**RE: Sydney Grammar School, Weigall Sports Complex: State Significant Development (SSD-10421):  
Response to Condition B1**

This letter on the Sydney Grammar School Weigall Sports Complex (SSD-10421) is written on behalf of Sydney Grammar School. It responds to SSD-10421 Condition B1 which states:

- B1. Prior to the issue of any construction certificate, the design of Building 1 (Sports Complex building) must be amended and revised architectural plans and documentation demonstrating compliance with the condition must be submitted to, and approved by, the Planning Secretary. The revised design must modify the design of that part of Building 1 located directly opposite 8 Vialoux Avenue (i.e. the building component east of the Building 1 stair core/Multipurpose Hall 4 and including the area above the program pool) to reduce the view loss impact experienced by the north facing living rooms within apartments 1, 5, 8 and 12 at 8 Vialoux Avenue. The amendments to the design must comprise (unless otherwise agreed with the Planning Secretary) the following:

Drawing Title
**WEIGALL SPORTS COMPLEX
BUILDING 01 AND BUILDING 02
APPROVED SSDA / RESPONSE TO B1
CONDITION COMPARISON (SHEET 1)**
Sheet Status
NOT FOR CONSTRUCTION

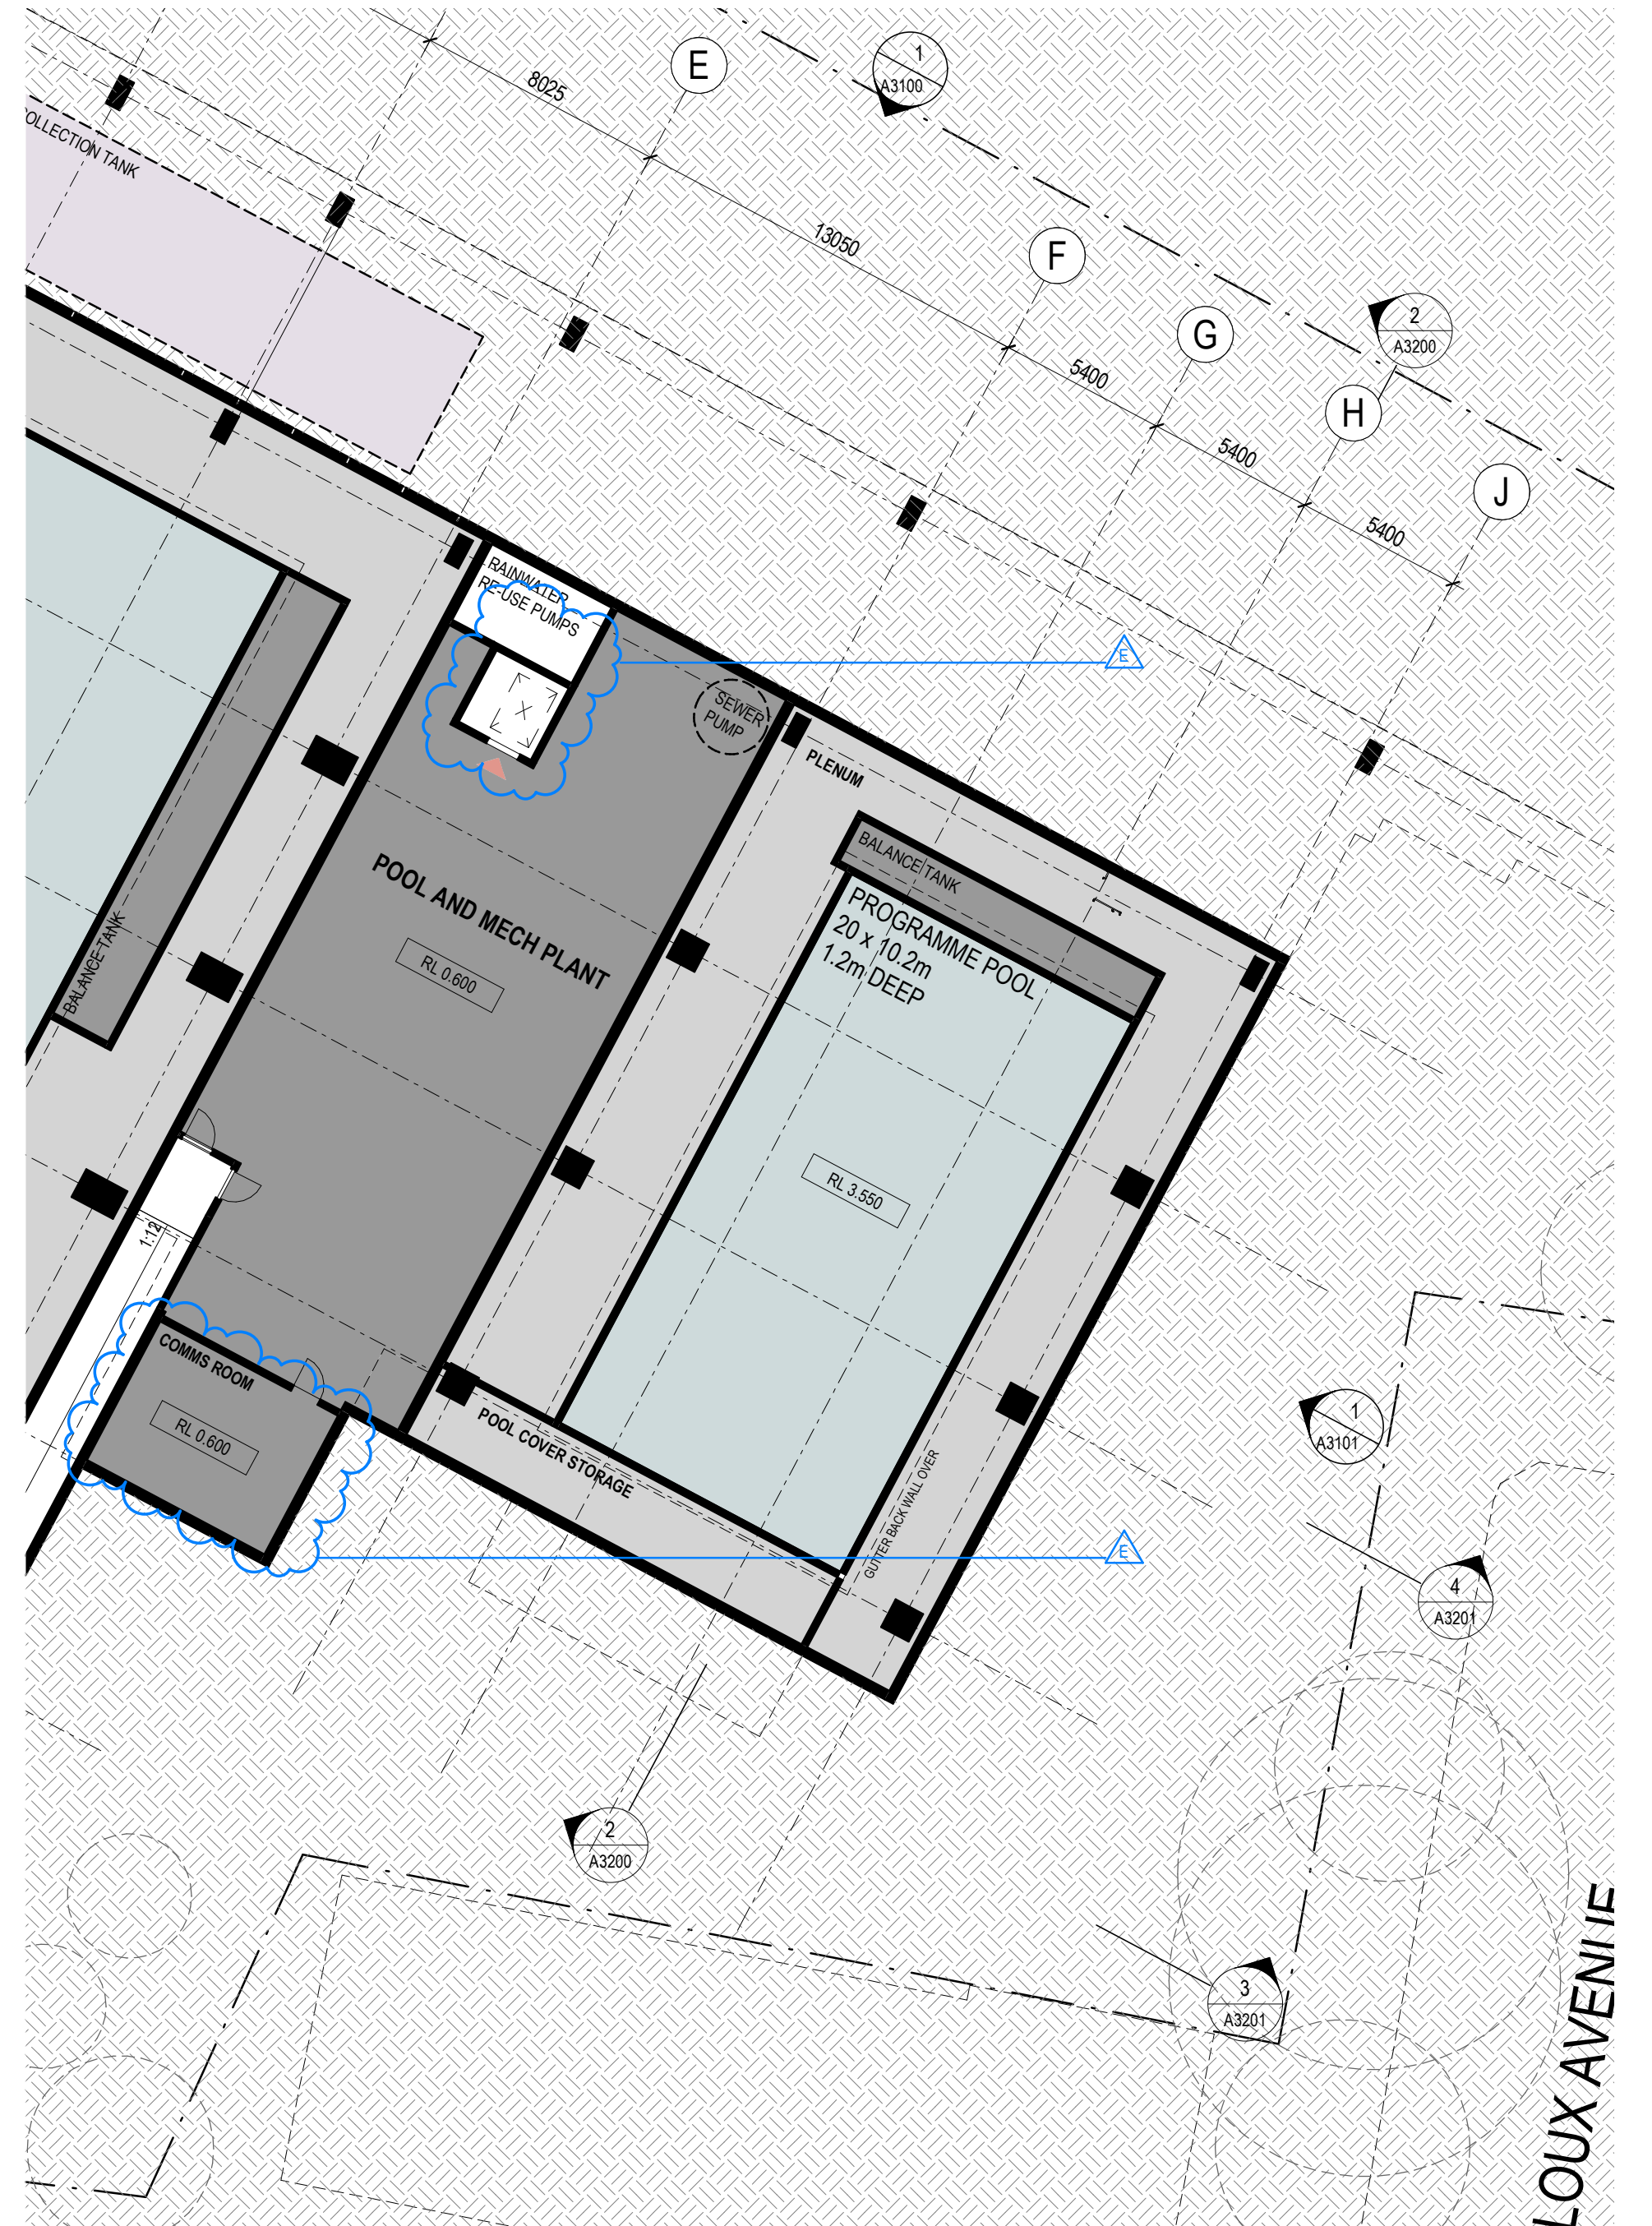
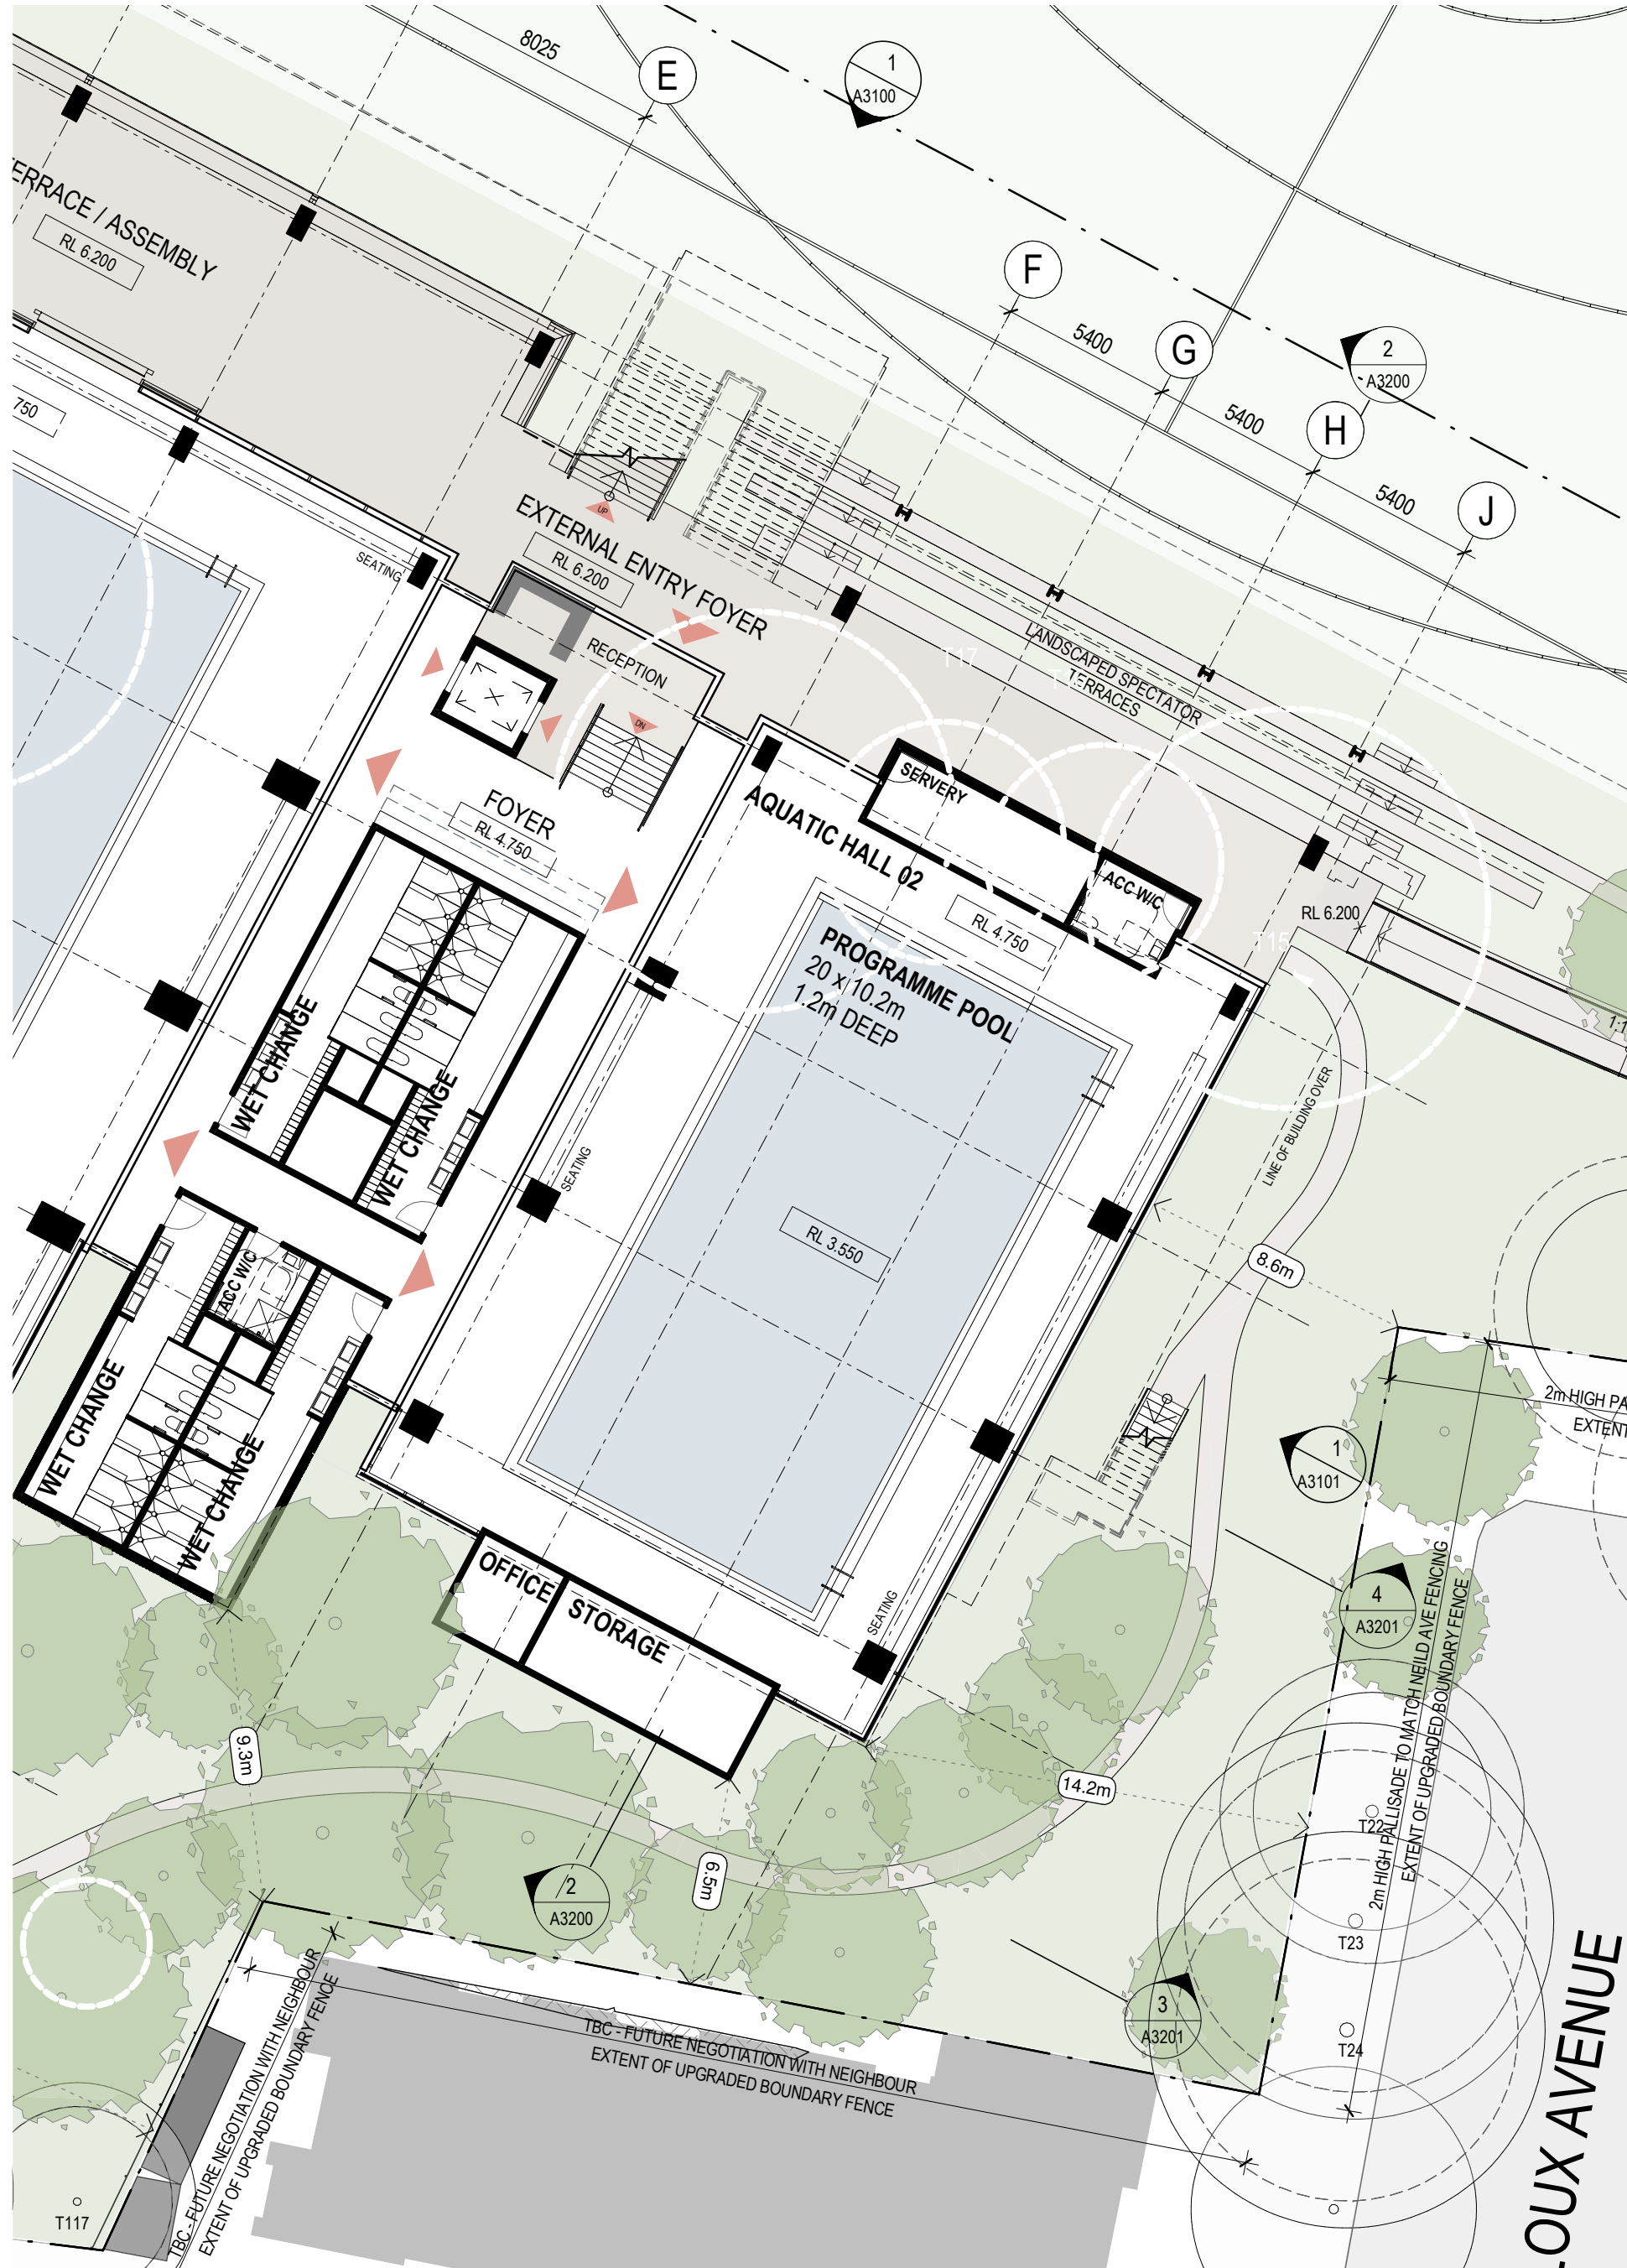
6. Redistribution of the approved plan area as Design Amendment 5 reduced the area of plant on the Mezzanine Level (-40.9m<sup>2</sup>), necessitating a similar increase to the area of plant at the Basement Level (+36.35m<sup>2</sup>). The additional Basement Level plant is beneath the Building 1 footprint and will not alter the envelope/external appearance of Building 1 or the approved landscape design. The design amendments result in a small overall reduction in the total plant area (-4.55m<sup>2</sup>), as summarised in **Table 1**.

Area of Plan	Approved SSD Revision C	Condition B1 Design Amendment Revision E	Proposed change
Mezzanine Plant (m <sup>2</sup> )	211.46	170.56	-40.9
Basement Plant (m <sup>2</sup> )	271.85	308.2	36.35
<b>Total (m<sup>2</sup>)</b>	<b>483.31</b>	<b>478.76</b>	<b>-4.55</b>
